Our Case Number: ACP-323024-25

An
Coimisiún
Pleanála

Re: Proposed elevation of local tertiary road (L-52214)
Cuan Na Loinge, Ceantar na nOileán, Conamara, Co. Galway

Please be advised that the Commission, in accordance with section 177AE(5) of the Planning and Development Act, 2000, as amended, hereby requires you to furnish the following further information in relation to the effects on the environment of the proposed development:

**PROPOSED SITE LAYOUT PLAN
 SAC EXTENTS**
 SCALE 1:500

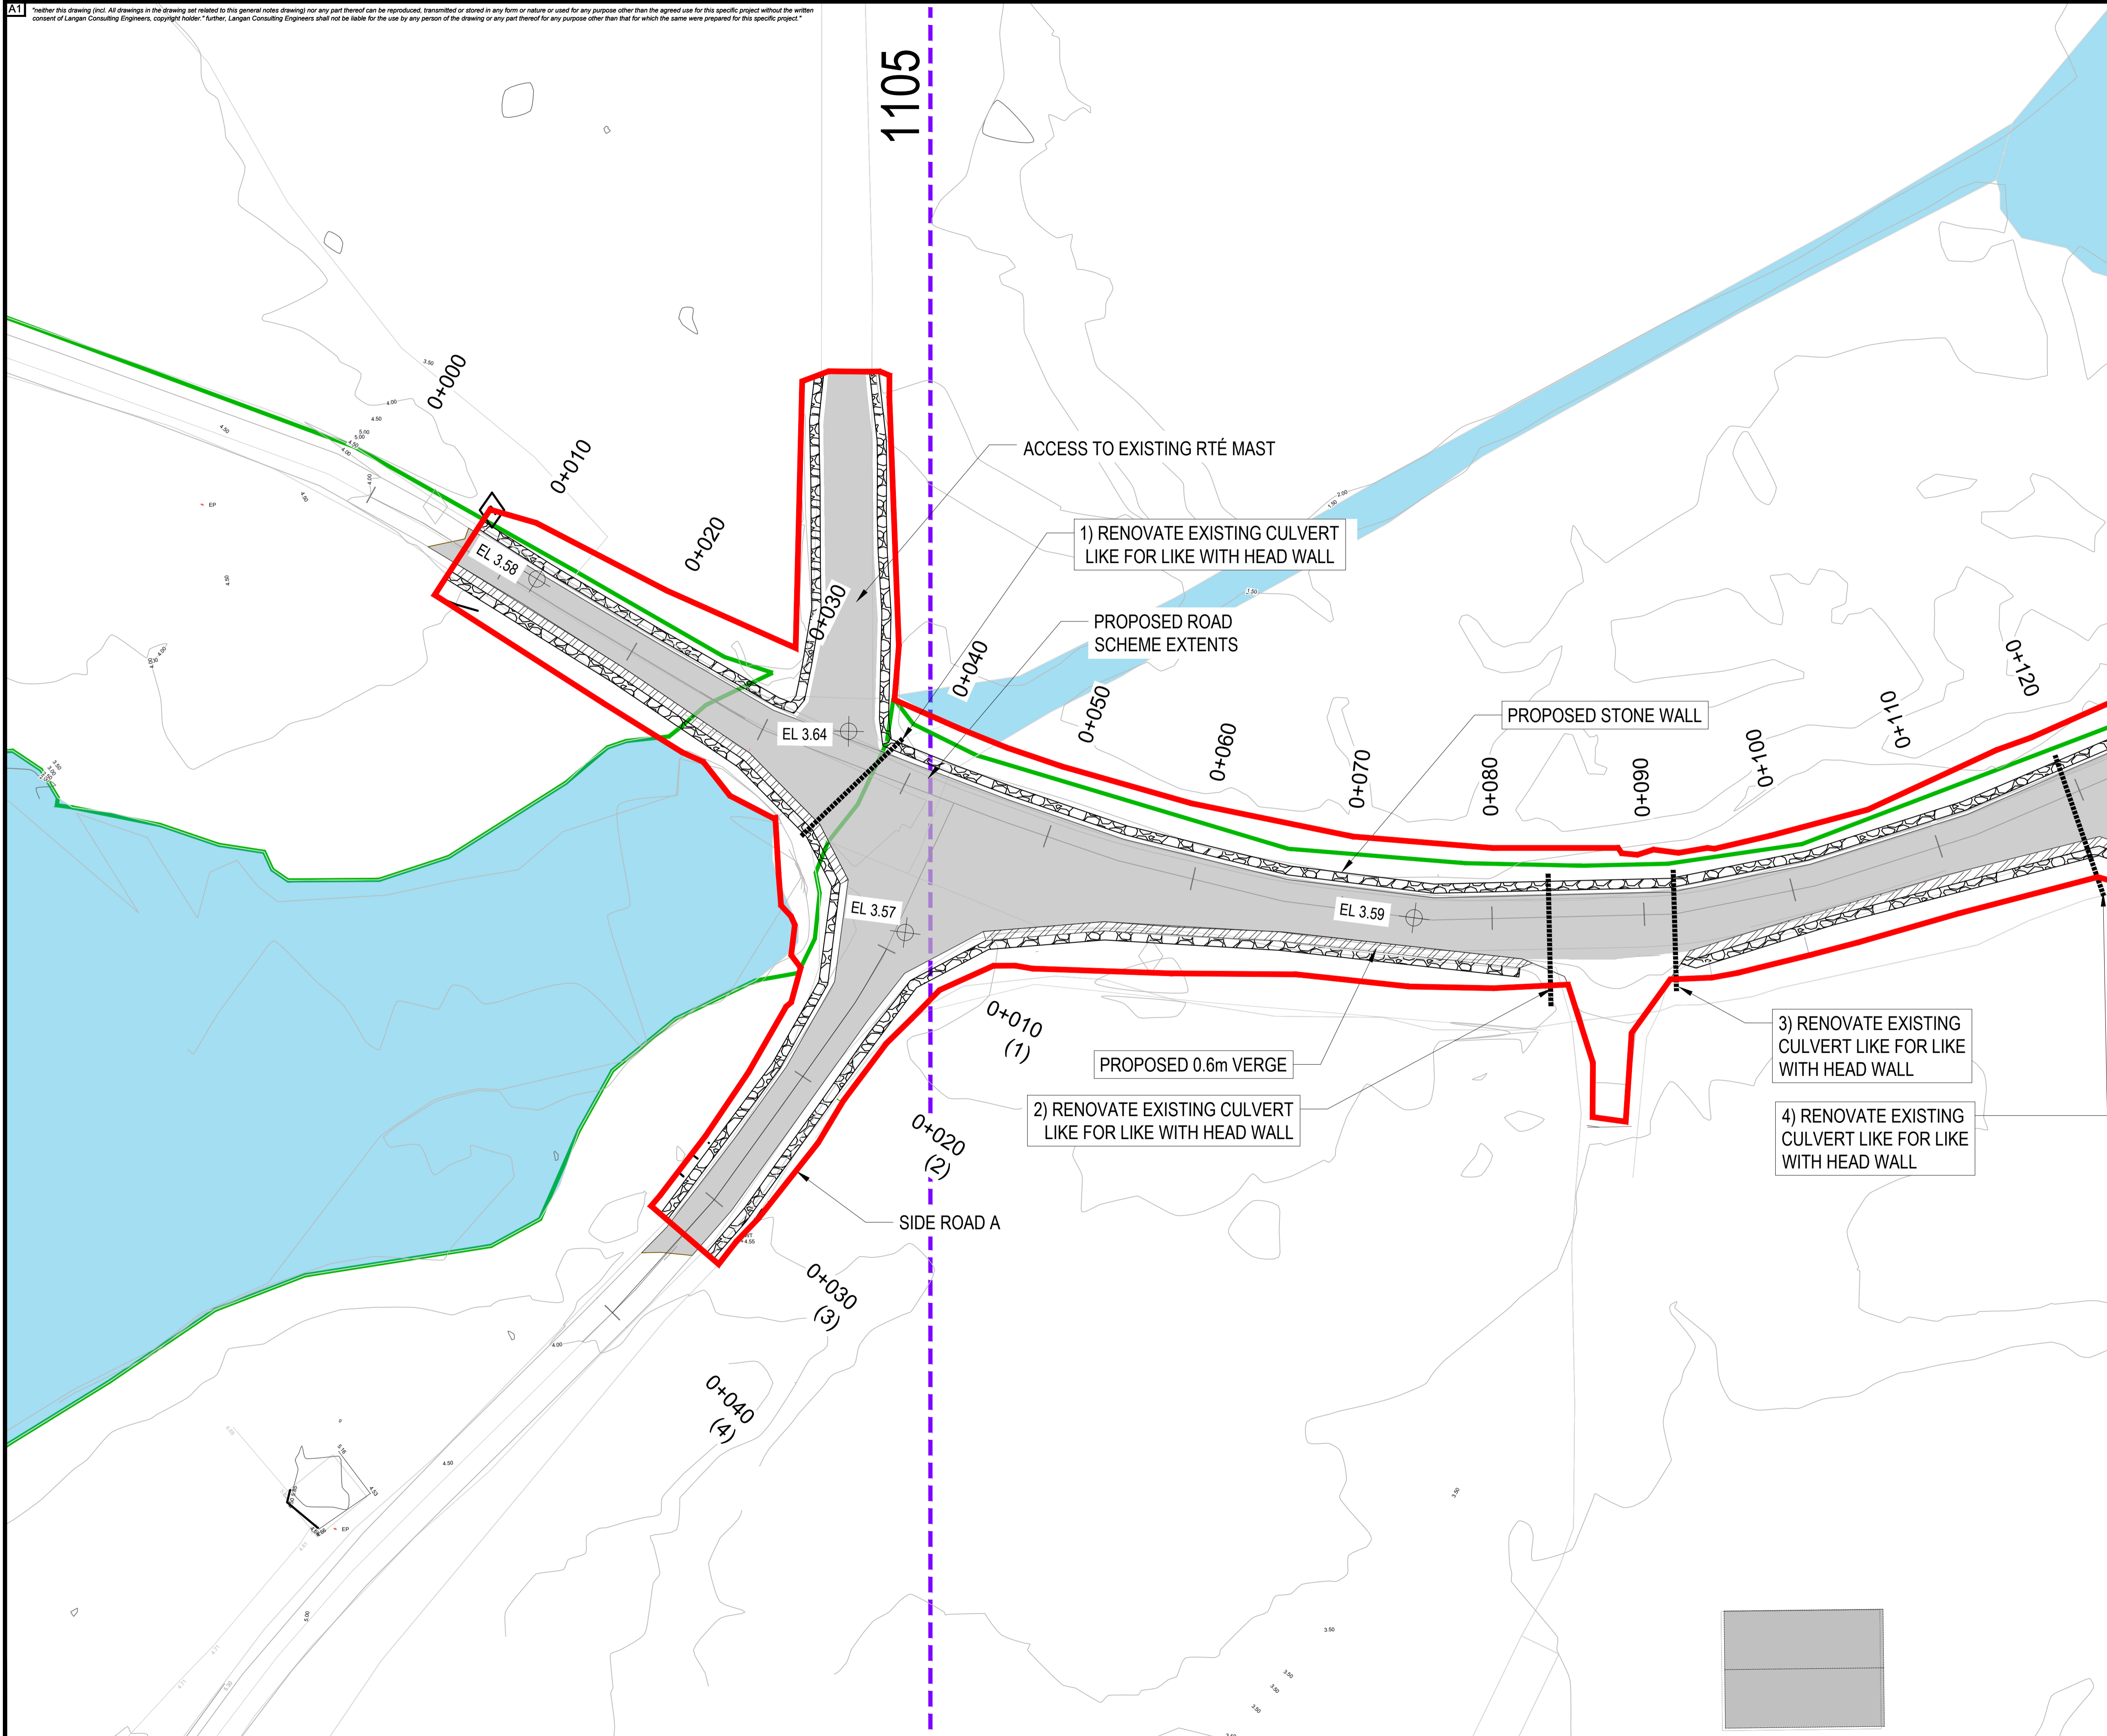
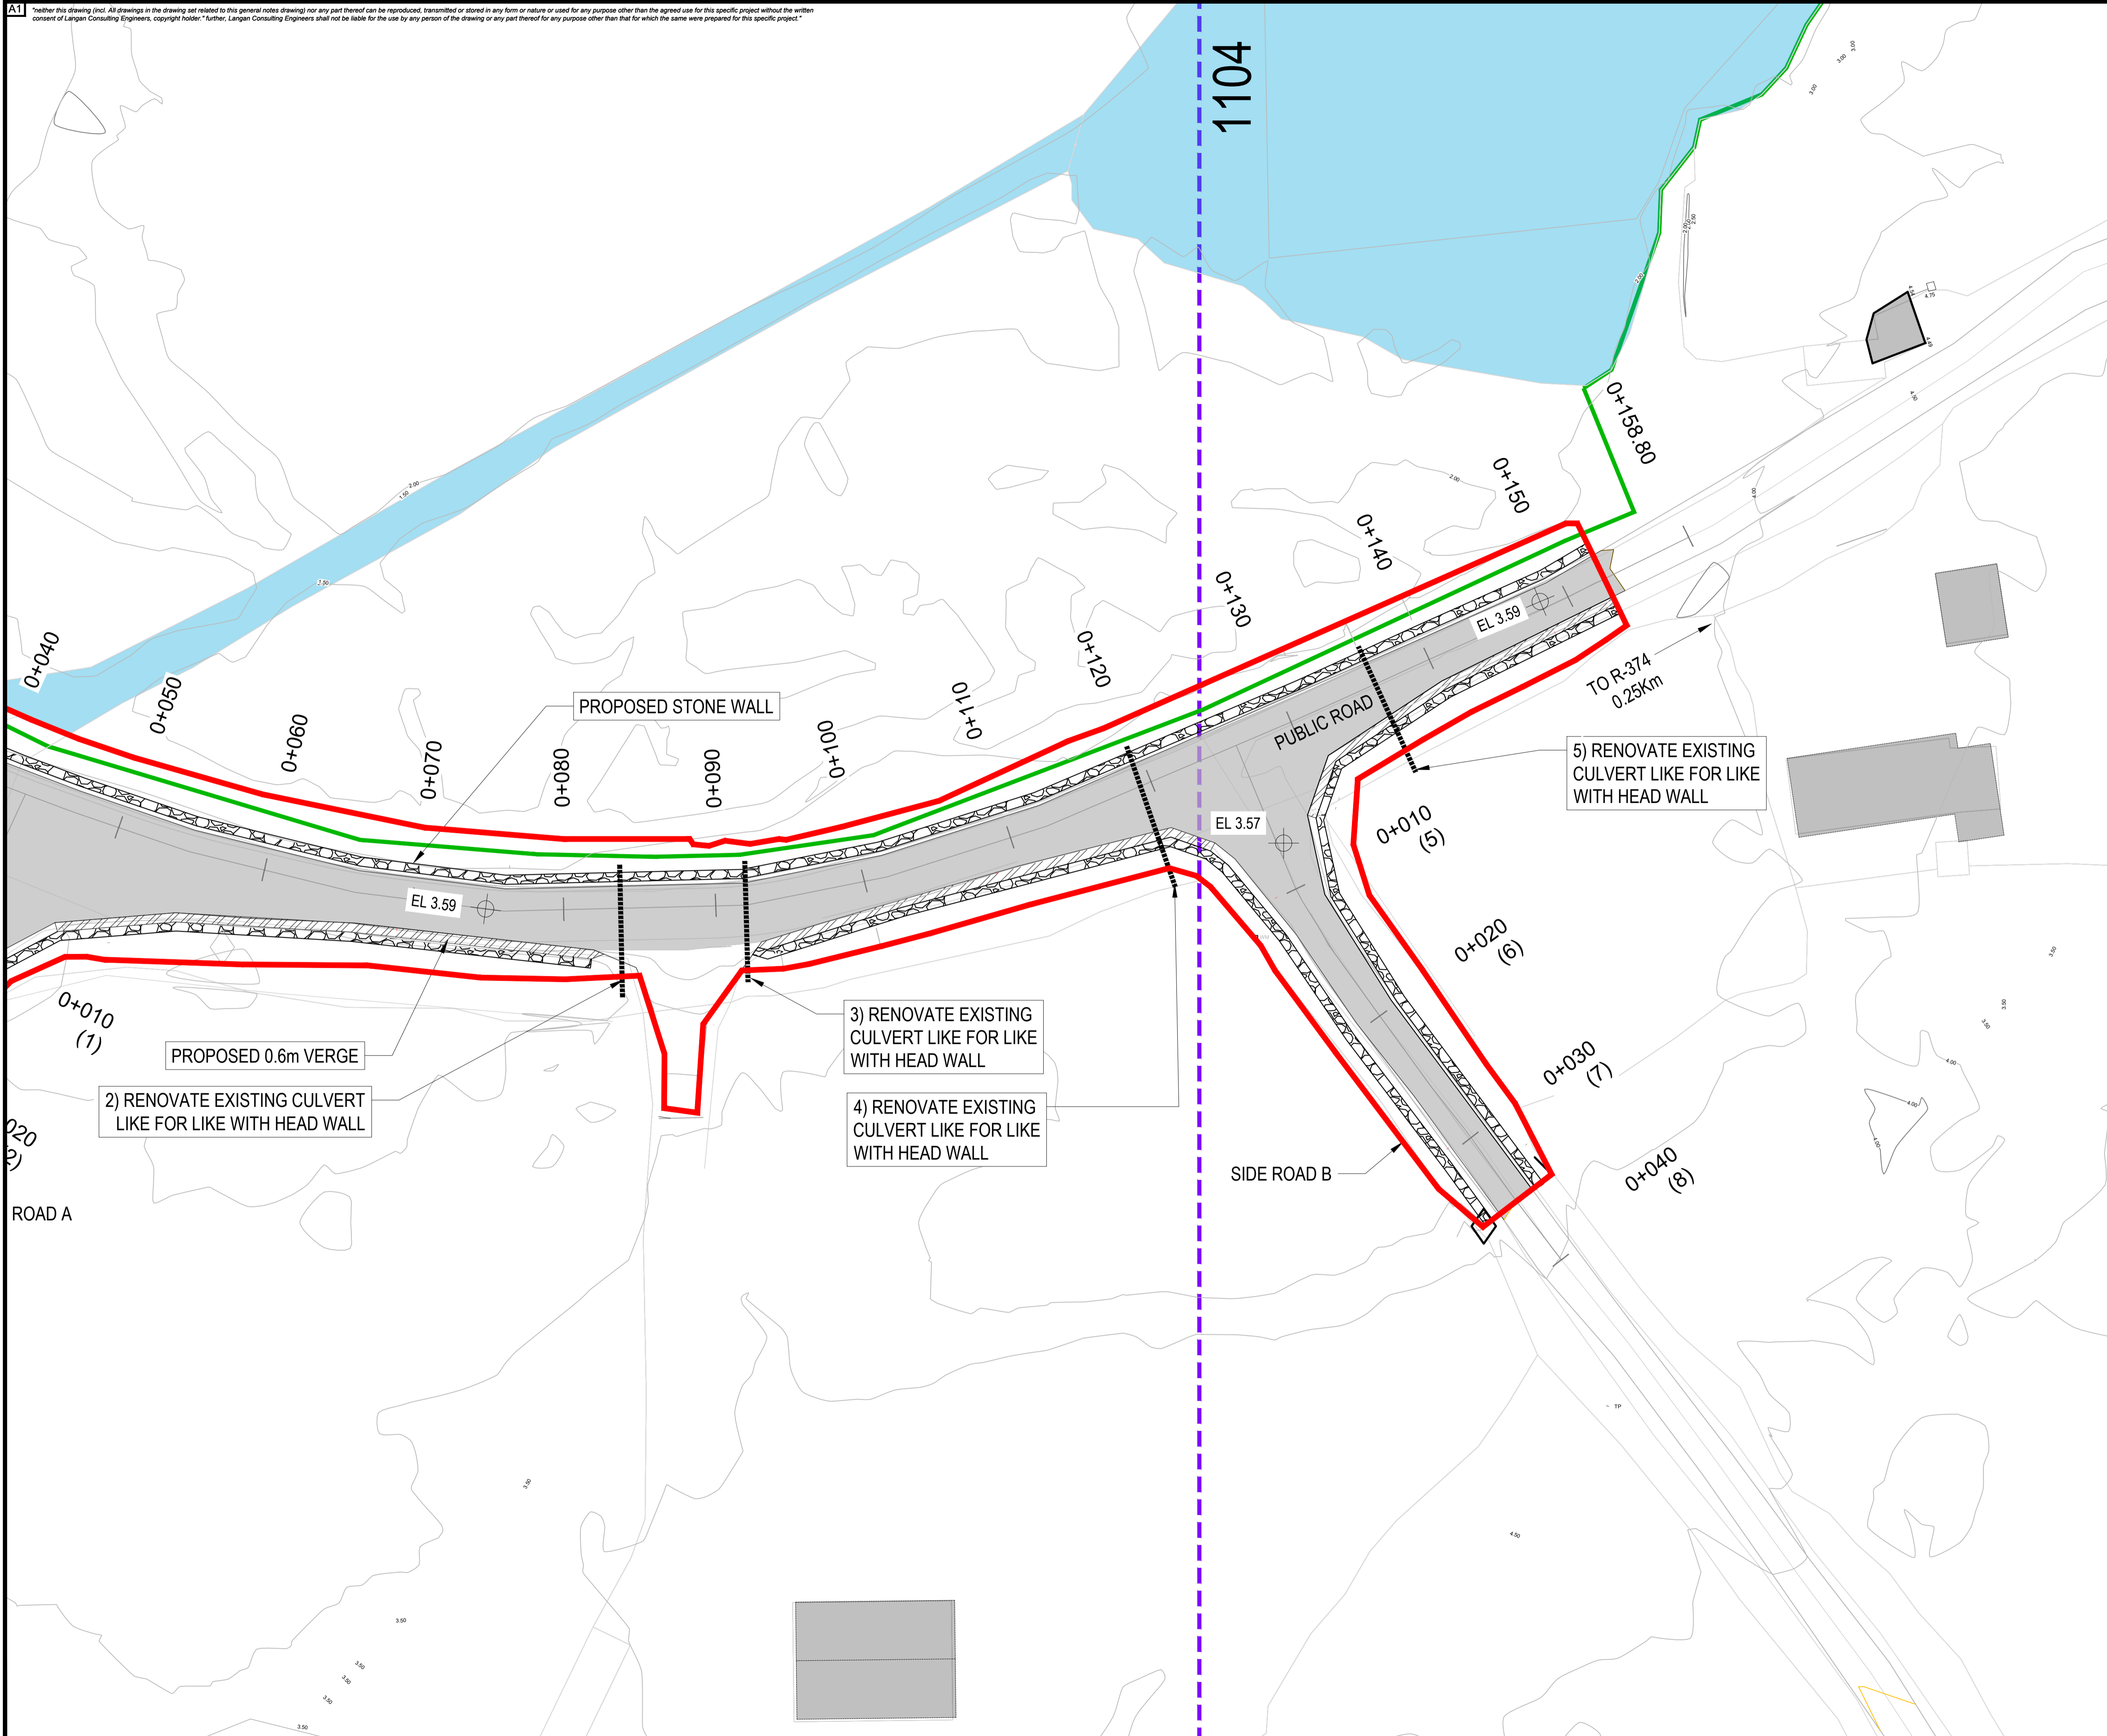
- i. The overlap between the application boundary, extent of the proposed works, the SAC boundary and Annex I habitat.
 - ii. Impact on Annex I habitat, as defined by its attributes and targets as detailed in the site-specific conservation objectives document for Kilkieran Bay and Islands SAC.
 - iii. Habitats providing a supporting function to the annex habitat.
 - iv. Habitats of biodiversity value beyond the Natura designation(s).
2. Detailed drawings (1:200 scale) showing the footprint of the proposed works, the SAC boundary and confirmed Annex I habitats/non-Annex I habitats within the application site boundary.

TYPICAL CULVERT CROSS SECTION AT ROAD

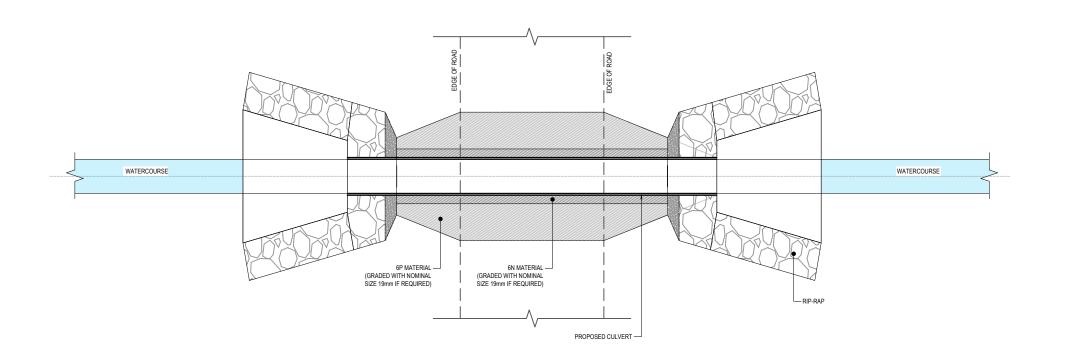
5. The nature and location of the proposed culverts and concrete works. Statements such as "The culverts should be designed with the hydrology of the site in mind" should be clarified/refined/removed from the NIS. The applicant shall provide project specific information with regard to what (if any) impact the operational phase and the installation of new culverts would have on the hydrological conditions and lagoonal specialist species of the Loch Fhada upper pools.
